**REPRESENTATIONS OF THE HISTORIC BUILDINGS AND MONUMENTS
COMMISSION FOR ENGLAND (HISTORIC ENGLAND)**

**DEVELOPMENT CONSENT FOR THE BRAMFORD TO TWINSTEAD
REINFORCEMENT
APPLICATION REF: EN020002**

Written Representations Summary

b) Hintlesham Hall and Hintlesham Woods

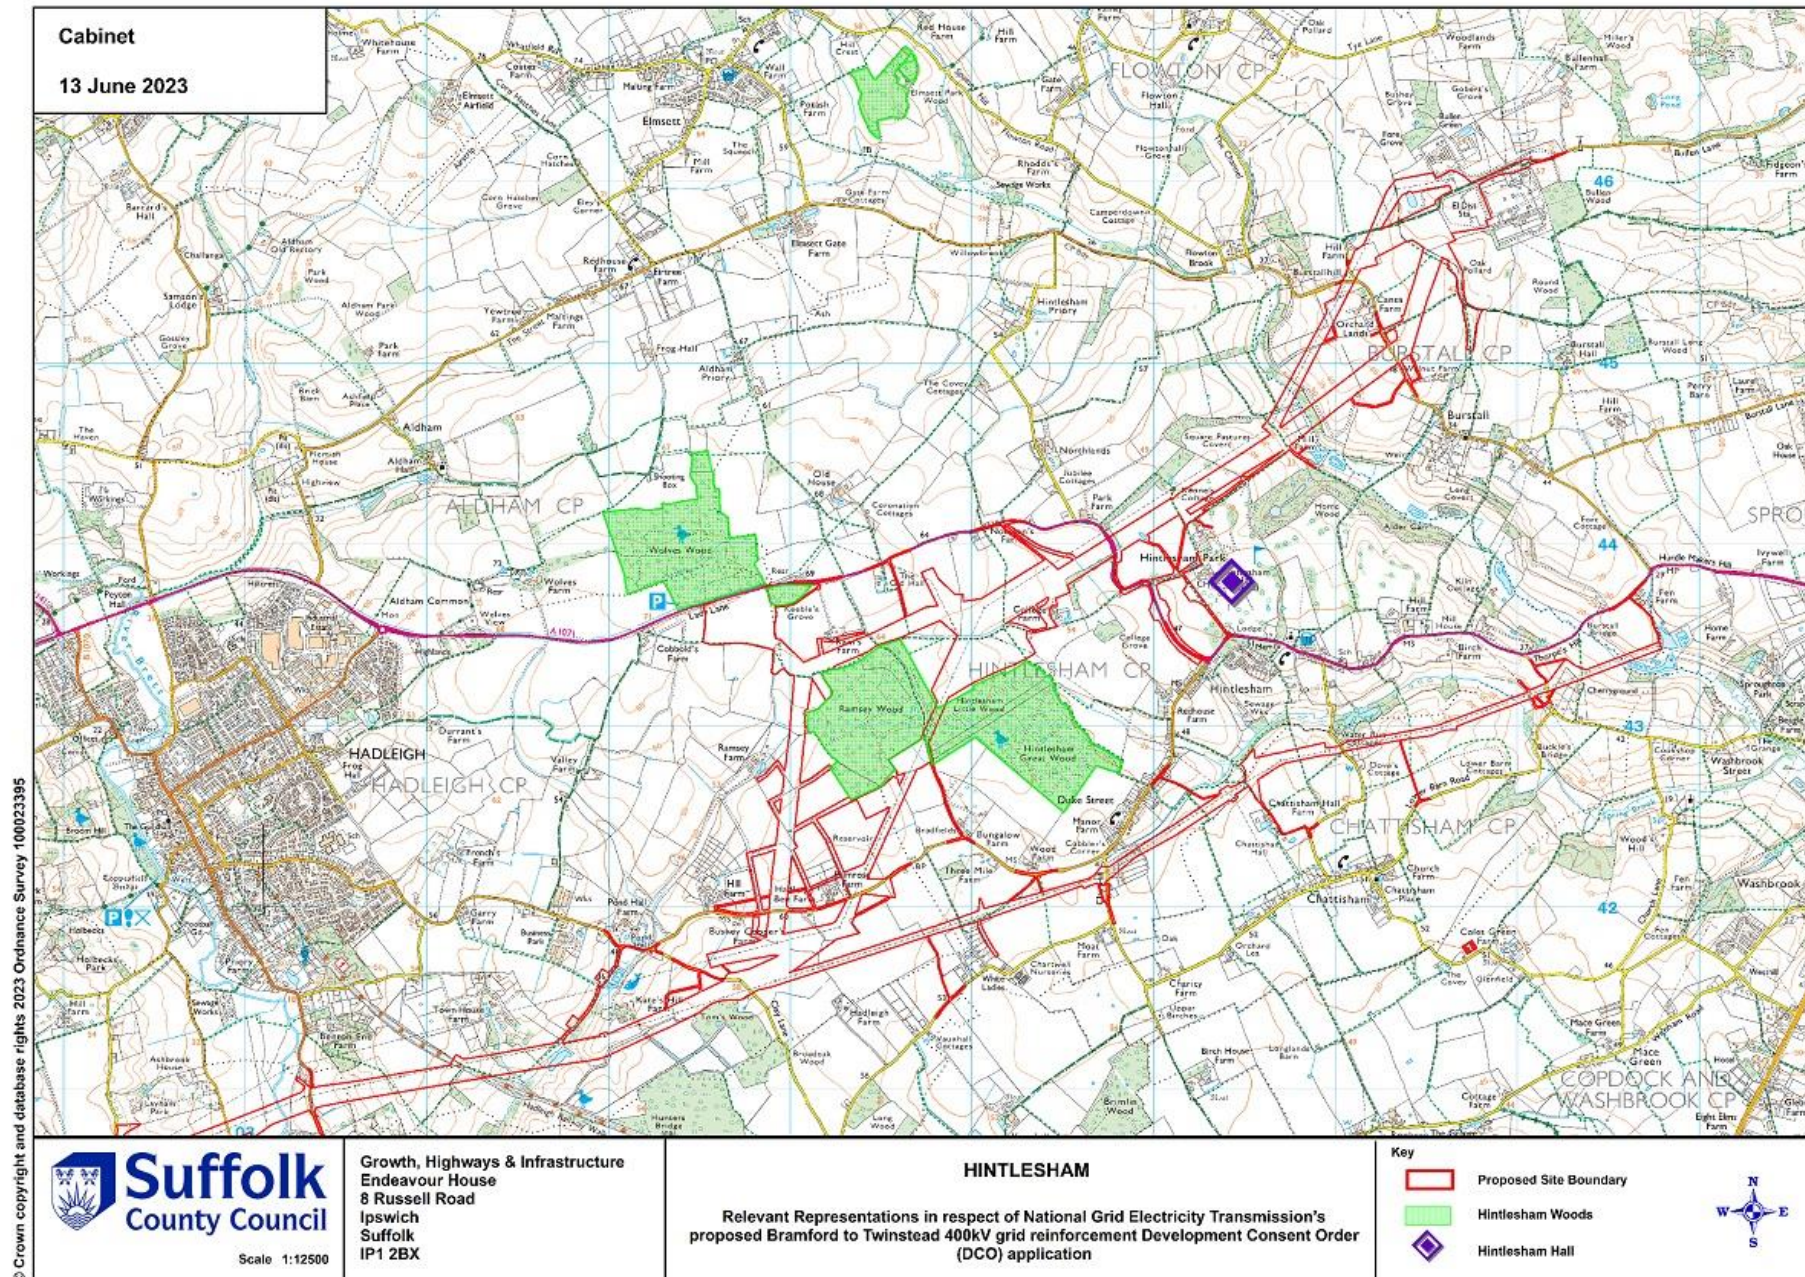
Historic England do have concerns regarding the layout of pylons RB3 and RB4 in this area and the limits of deviation. We would therefore like to see additional measures added to protect the view out from the stable block of Hintlesham Hall (shown in viewpoint HV01) and prevent the relocation of pylons RB8 and RB9.

We would recommend these comments be addressed, and additional information and clarification provided by the applicant. We would expect revised documents, addressing these comments, to be reissued for examination.
